**The Hinkley Point C (Nuclear Generating Station)
(Amendment) Order 2021**

Made - - - - *16th December 2021*

This Order follows an application under paragraph 2 of Schedule 6 to the Act for a non-material change to allow for changes to the site layout and design of buildings and structures within the

DRAWING TITLE
Hinkley Point C Development Site
Unit 1: Cooling Water Pumphouse / Forebay / Outfall Pond
/ Service Access Buildings 5 and 7
Elevations 5(2)(i)
Regulation 5(2)(i)
PROJECT REFERENCE NO.
HINK-A2-HP-01-GE-001

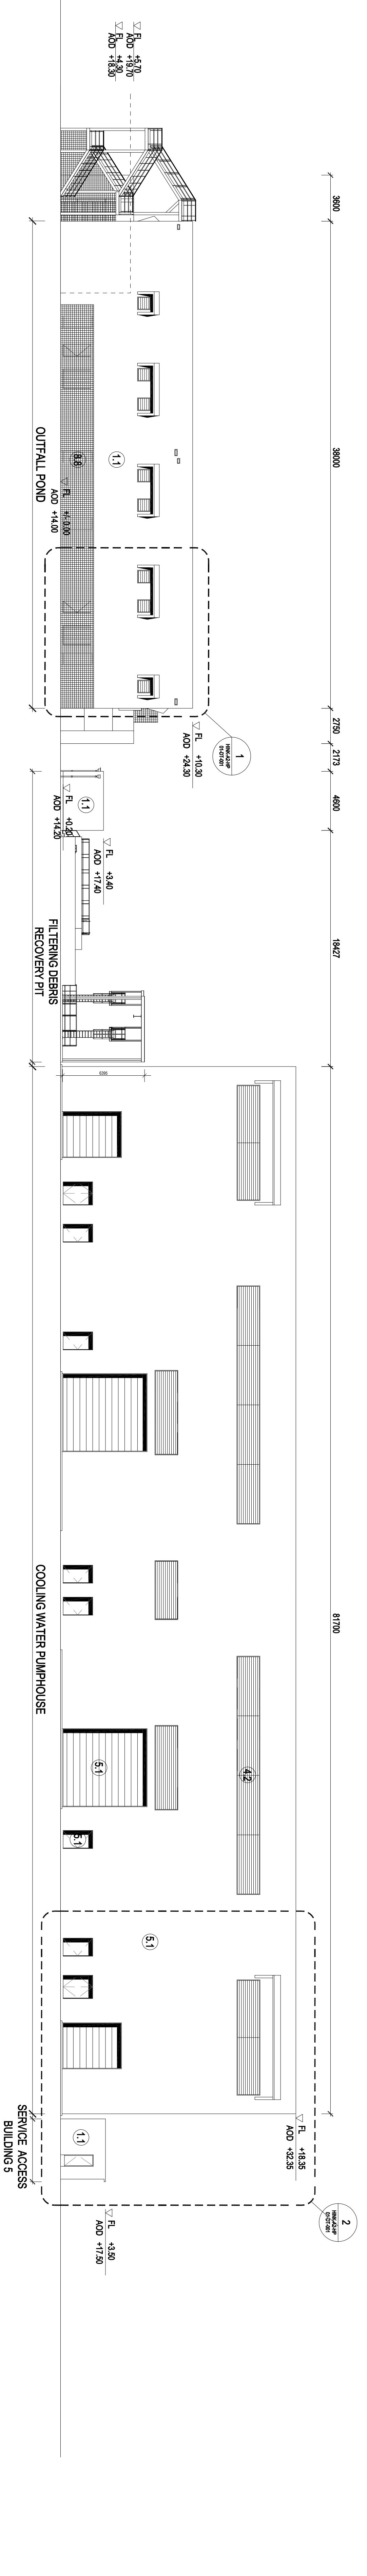
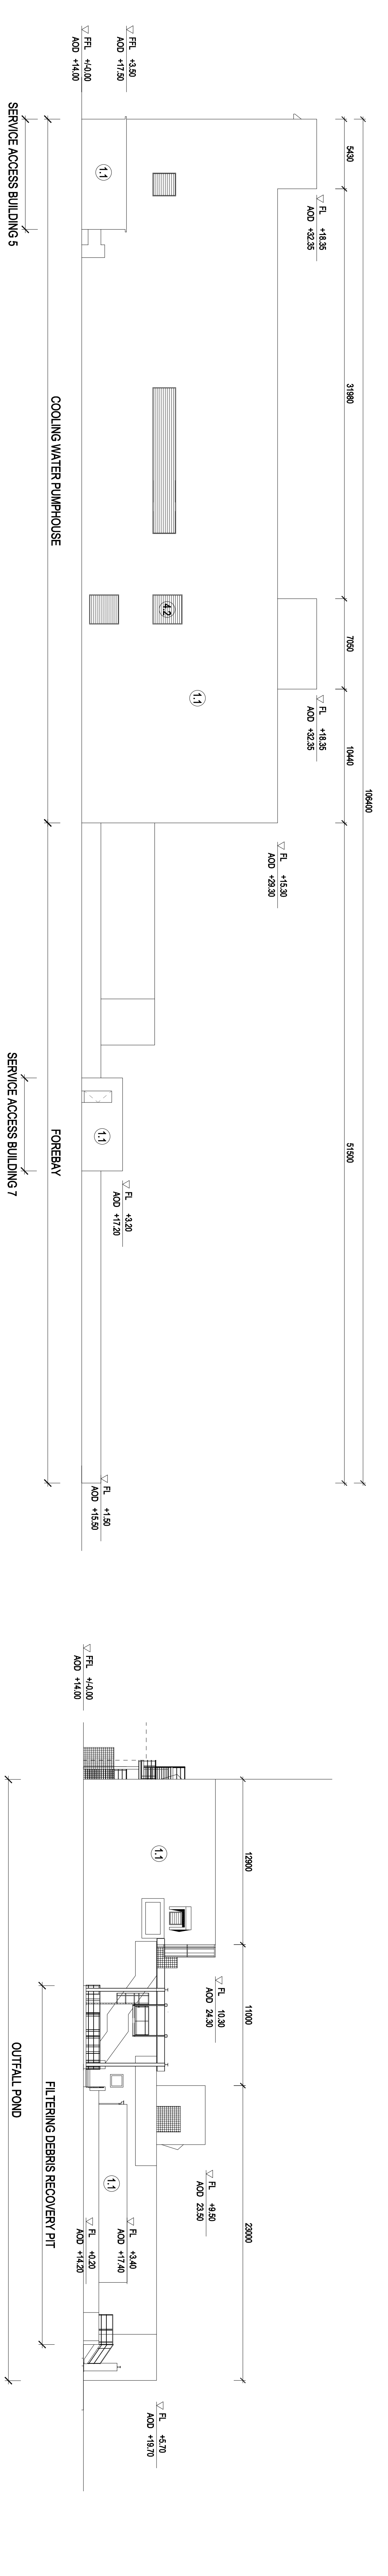
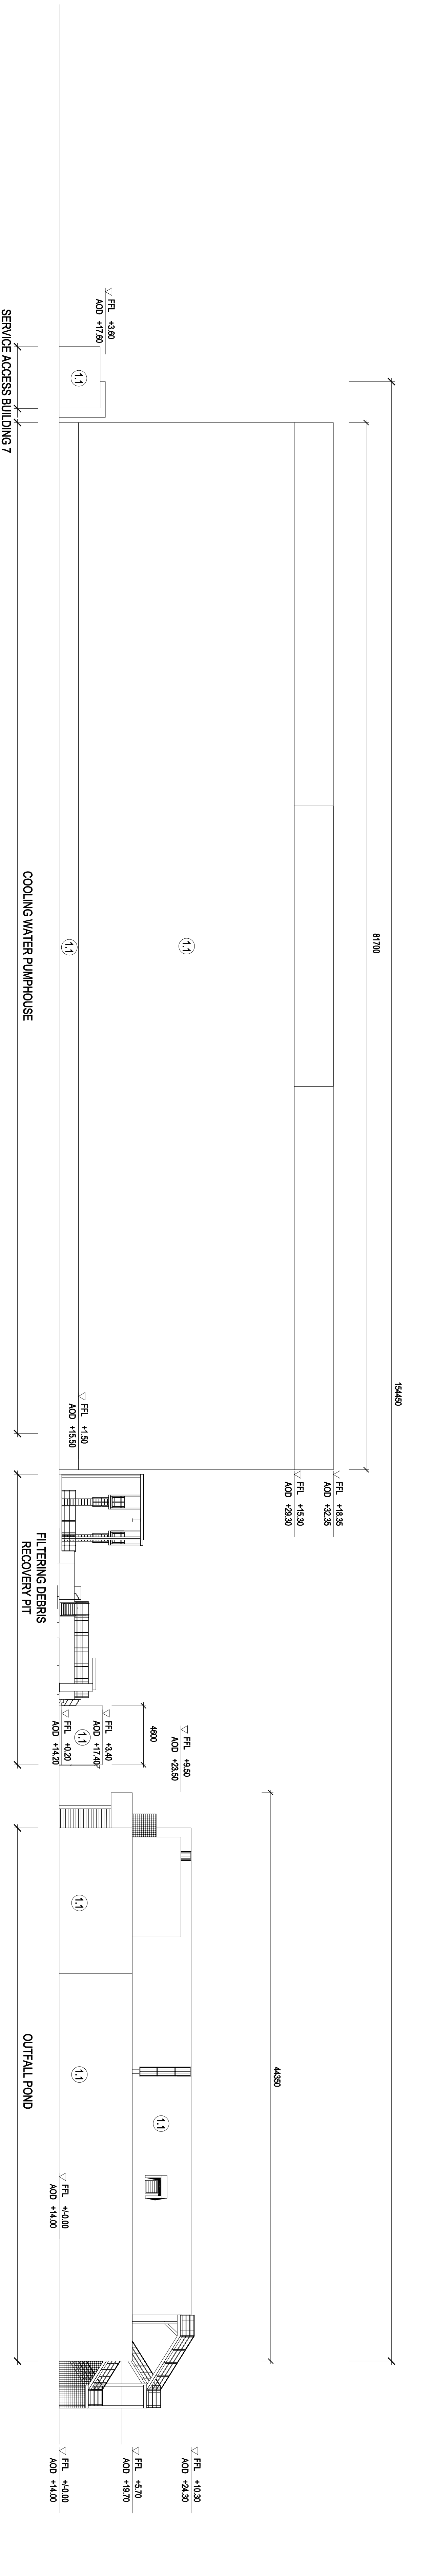
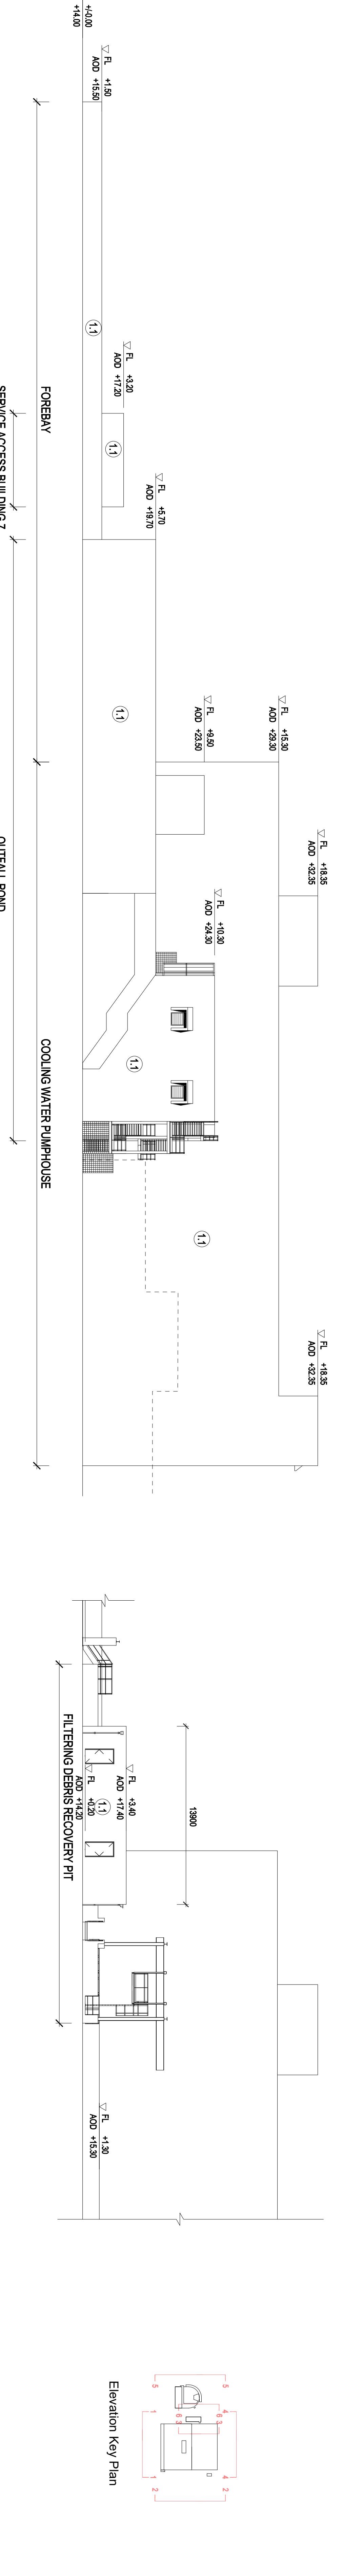
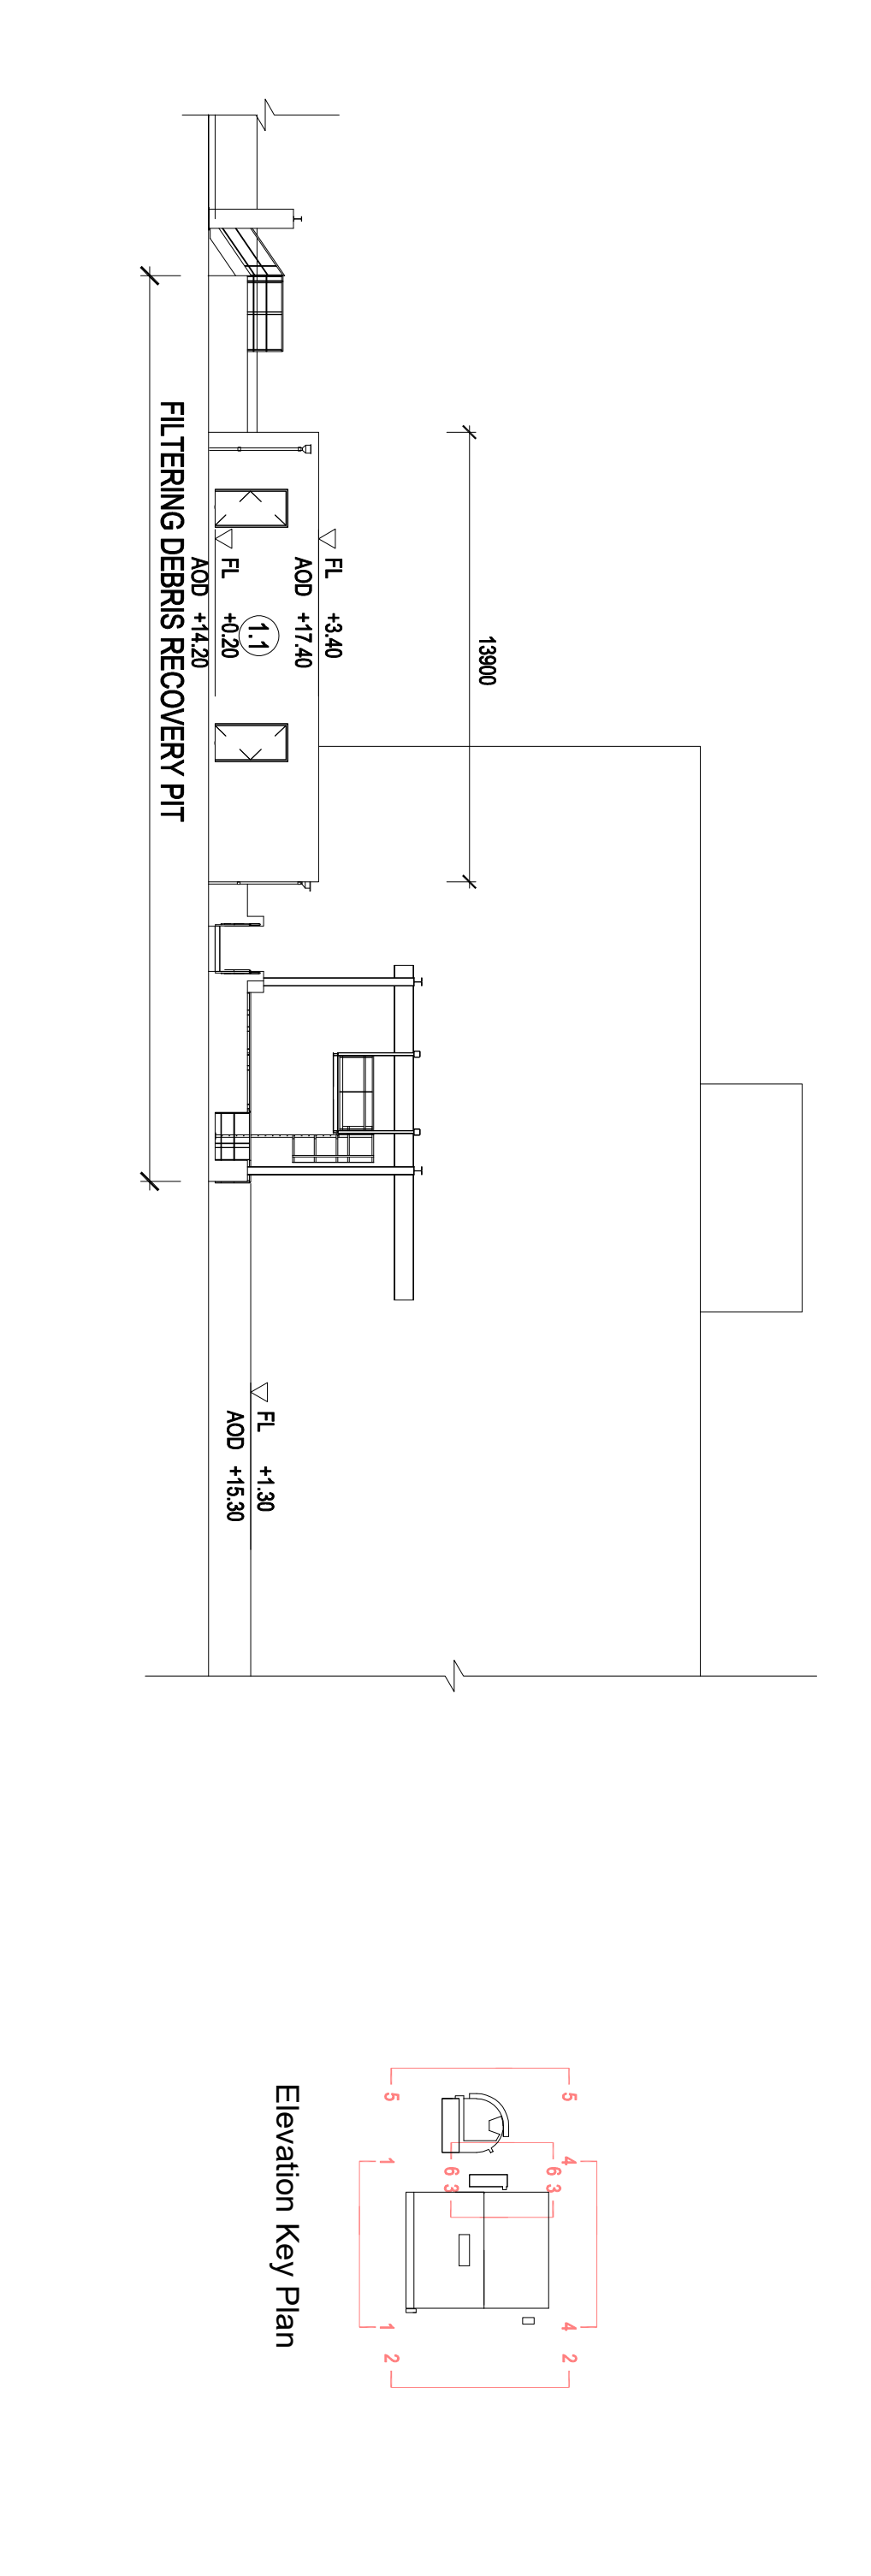
(2) For the approved plans listed in paragraph (3) substitute the approved plans listed in Schedule 1 to this Order.

DRAWING TITLE
Hinkley Point C Development Site
Emergency Response Centre (HUM)

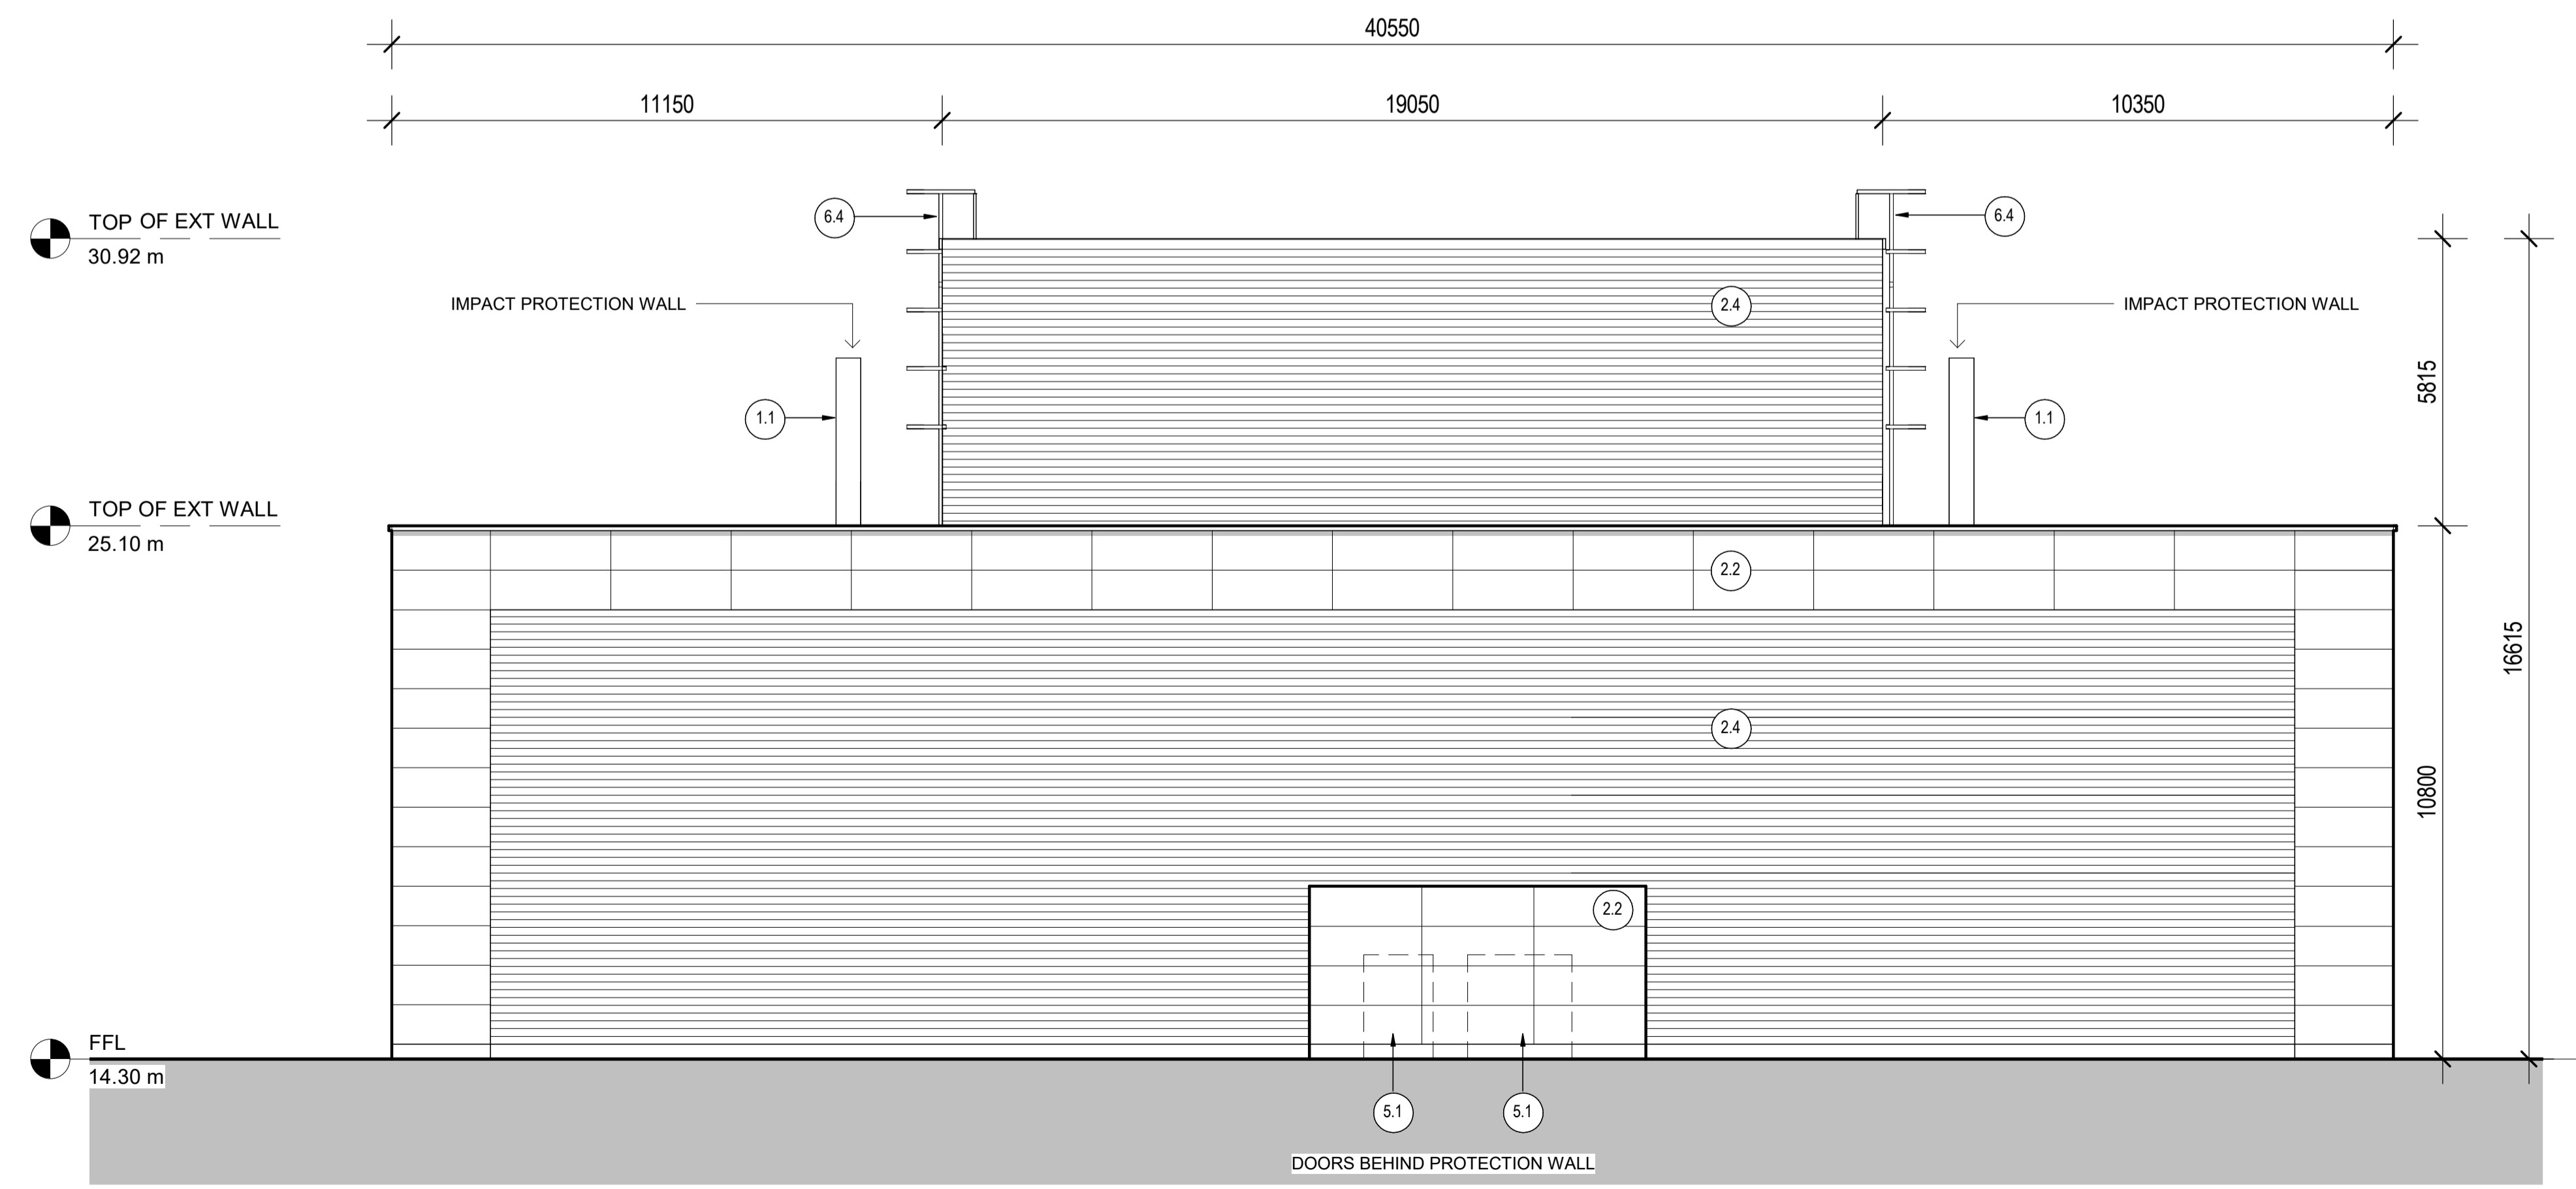
(6) After the approved plans listed under the heading “Services Ventilation Building” insert the lists of approved plans under the new headings “Off Site Delivery Checkpoint”, “Emergency Response Centre” and “Emergency Response Energy Centre” as set out in Schedule 2 to this Order.
